Department of Planning and Environment

**Dalswinton Sand and Gravel Quarry (SSD-9094) –
EIS**

Liz Rogers
Manager Assessments
Department of Planning and Environment: Water
3 March 2022

Detailed advice to DPE Planning & Assessment regarding the Dalswinton Sand and Gravel Quarry (SSD-9094) – EIS

Figure 6-12: Detail of Raised Bund between Hunter River and Quarry (Final Landform)

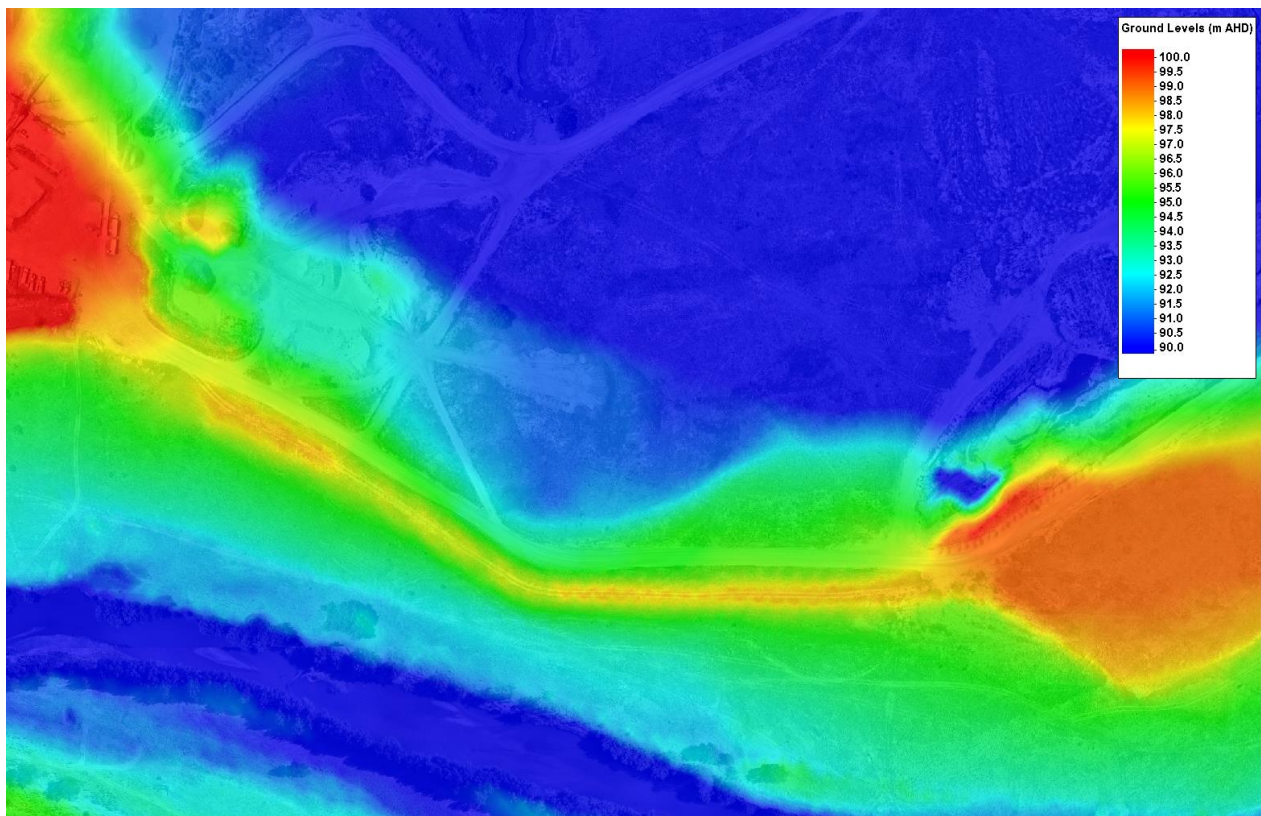
Details on the erosion associated to the likely levee/bund failure are not discussed other than to note that if a failure is unacceptable then it should be armoured, or the levee's height increased. The assessment should identify whether or not the erosion and conveyance of the sediment of the levee/bund will have any adverse impacts on watercourses, riparian land or water quality. The assessment should also detail whether or not such an event would lead to an increased risk of erosion in the operational area, or diversion of flow from the current watercourse and any associated impacts to watercourses, riparian land or water quality.

- a. Detail whether or not there is a risk of erosion to the existing or final form of the quarry and if this will impact any watercourses, riparian land or water quality.
- b. Detail whether or not a failure of the levee/bund would lead to an increased risk of erosion or diversion of flow from the current watercourse and any associated impacts to watercourses, riparian land or water quality.
- c. Clarify the flow path of watercourses on site and clarify whether the proposed work area is to cause any impacts to the third order watercourse (that runs along the northern part of the site) and how these would be mitigated.
- d. Show consideration to the NRAR Guidelines for Controlled Activities including setbacks.

Figure 8.1 Maximum combined drawdown

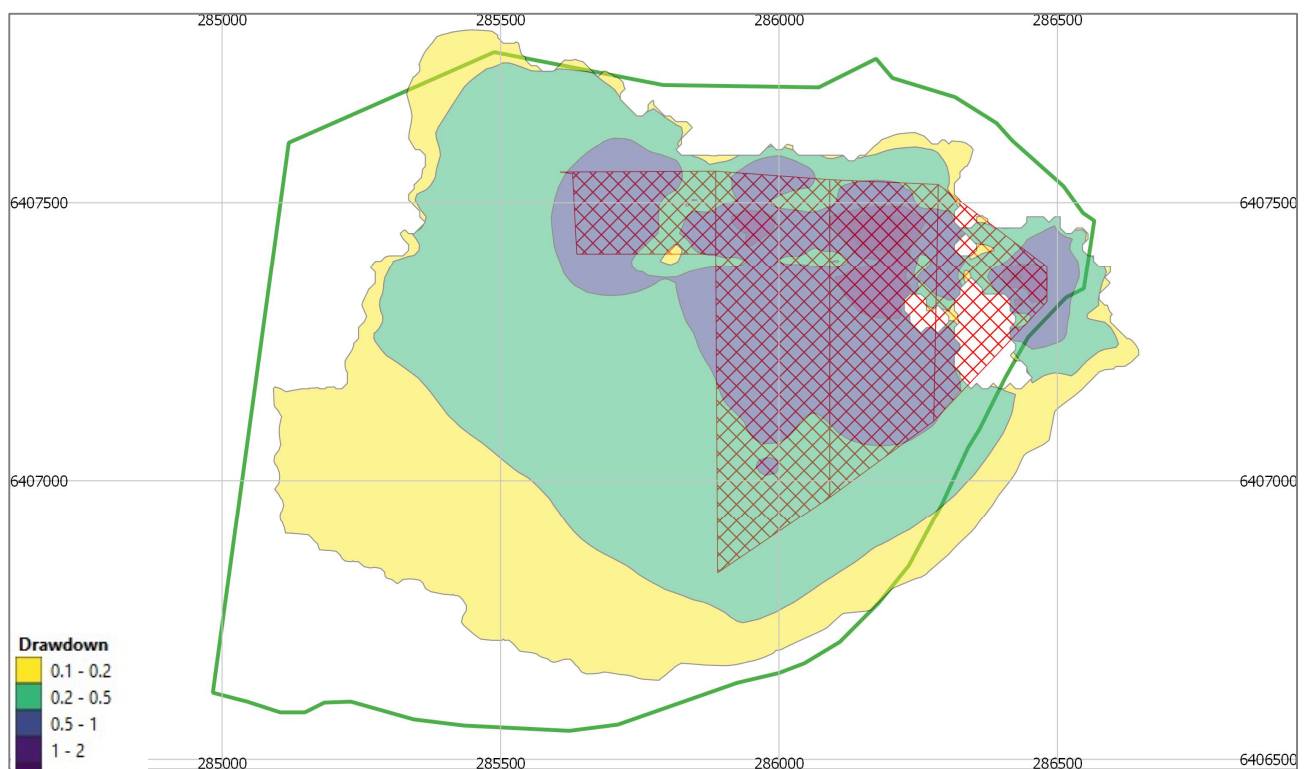
The model comes with some limitations which result in low confidence in the model prediction. Uncertainty prevails on the model prediction due to underestimated groundwater take, inability to account river and aquifer seepage into the quarry pit, and low confidence on model predictions. For example, the (steady state) model uses constant head boundaries on both ends of the river, this doesn't allow for estimation of impact on the river considering the extraction is proposed to the depth of bedrock and below the river bed elevation adjacent to the Hunter River. Furthermore, evaporation from the pit as a result of river and aquifer seepage, and groundwater take with aggregates are not considered as model input.

Evaporative groundwater loss is predicted using 25 pit cells in the model to represent each year of operation. The assumption is that each pit will be rehabilitated immediately after completion of extraction of aggregates. However, in reality the majority of rehabilitation of the voids takes place at the end of 25 year operational period. As such, the pit voids will drain groundwater and the evaporative losses increase over the time. Therefore, the model predicted evaporative groundwater loss is an underestimation.

The model failed to include stress components such as groundwater take from the pits for processing/dewatering, groundwater take with quarried aggregates and maximum evaporative losses from the pit until rehabilitation.

- 2.1** The proponent should:
- Review the conceptualisation and how the conceptualisation is transferred to the numerical model to ensure aquifer interference activities and their impacts are represented in the groundwater model and have the ability to predict potential impacts on the river and aquifer (and other groundwater values) during and post closure of the quarry operation.
 - Assess the proposal against the Aquifer Interference Policy (AIP) requirements and include the summarised responses using the Aquifer Interference Assessment

- c. Review groundwater inputs to include the volume of groundwater take that includes: evaporative groundwater loss from the voids; incidental take with quarried aggregates; and dewatering and take for processing demands.

**FIGURE 3.3**  
**Proposed Water Management System Plan**

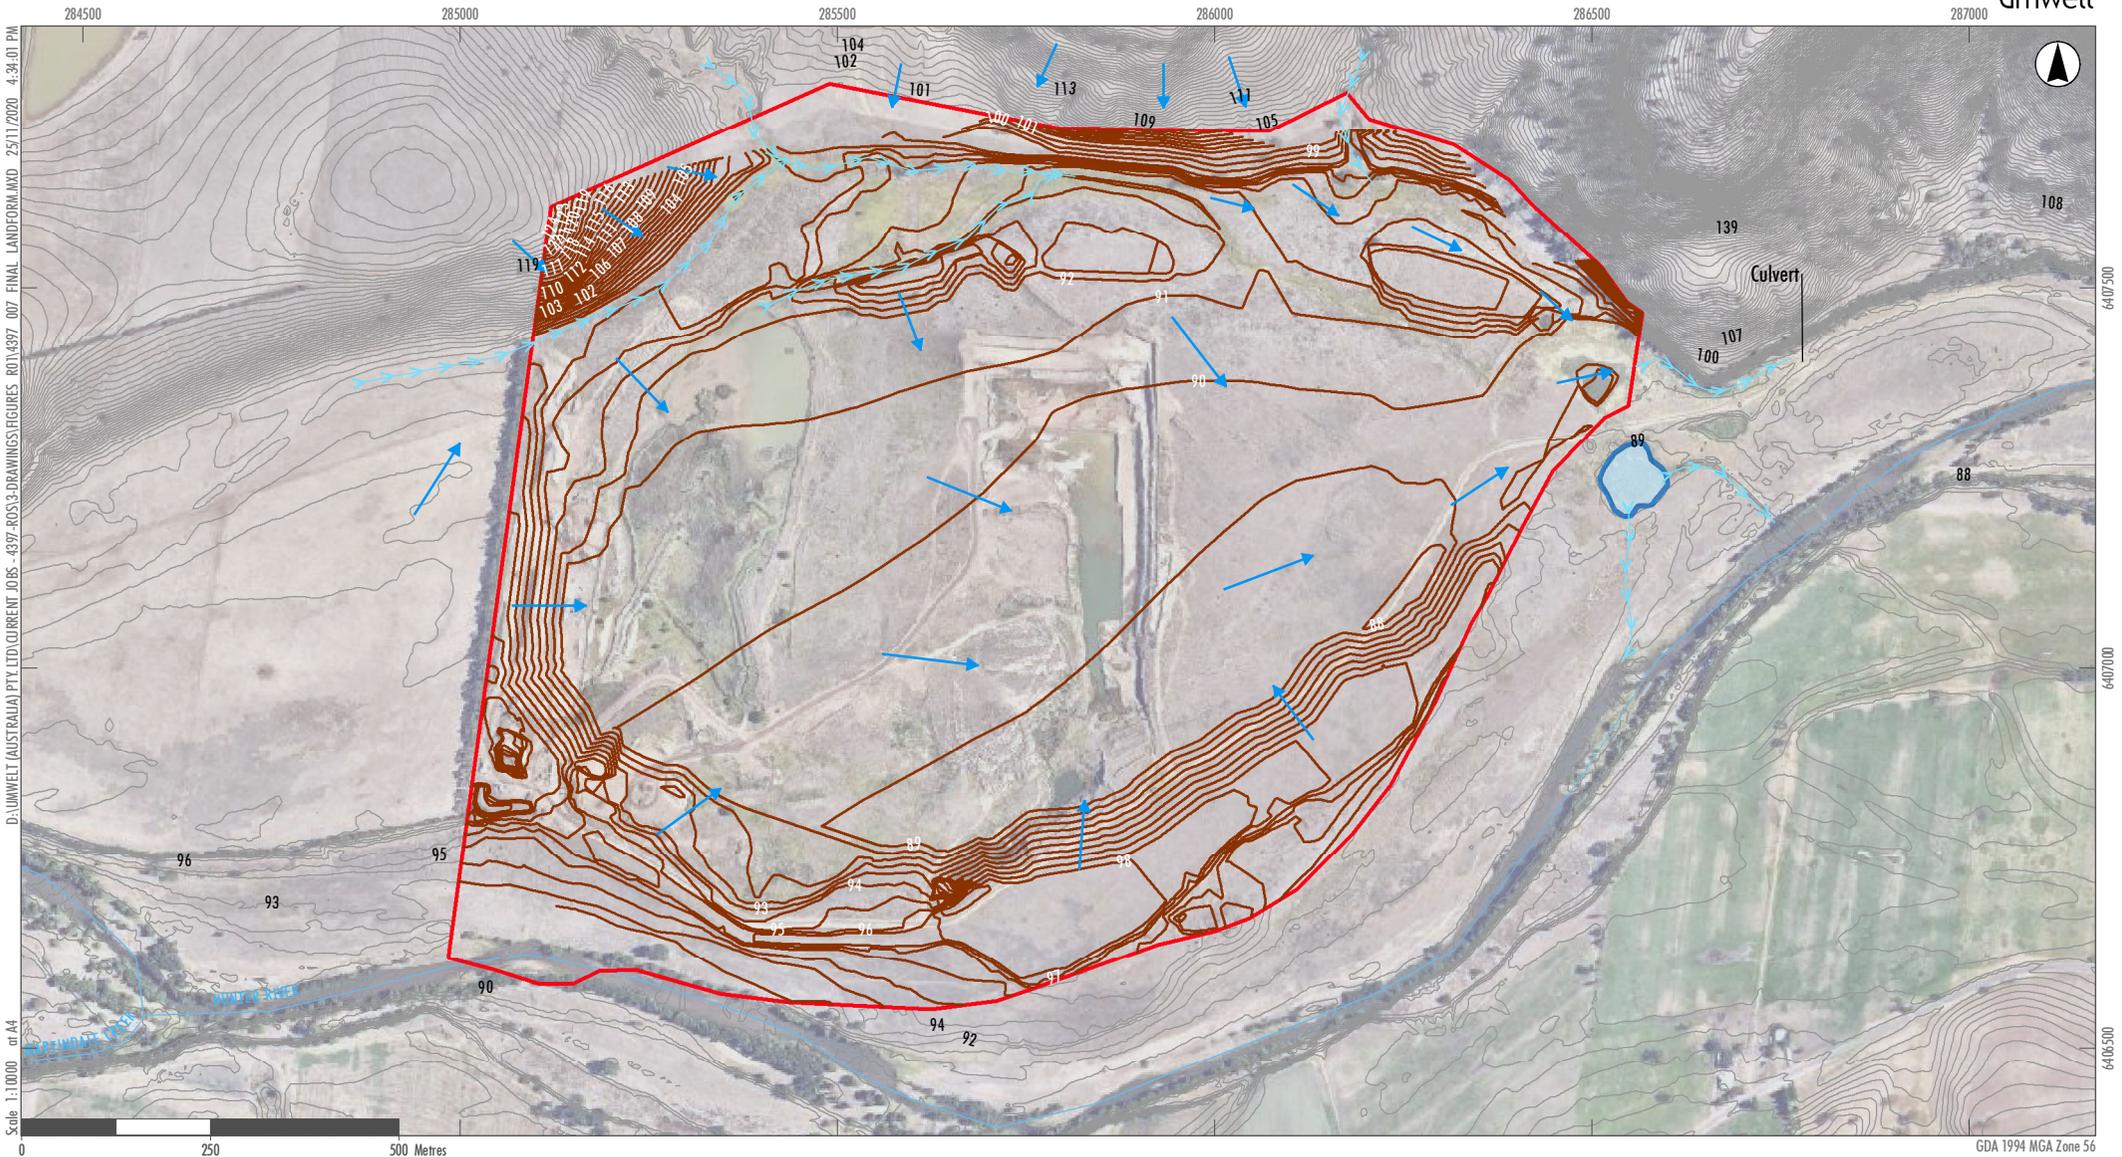
There are two mapped watercourses on site, a 2nd order in the north eastern corner and a 3rd order running the northern part of the site, but the exact flow path of these is unclear. The flow path of the 3rd order watercourse is particularly unclear within the site, and potentially will run through a works zone.
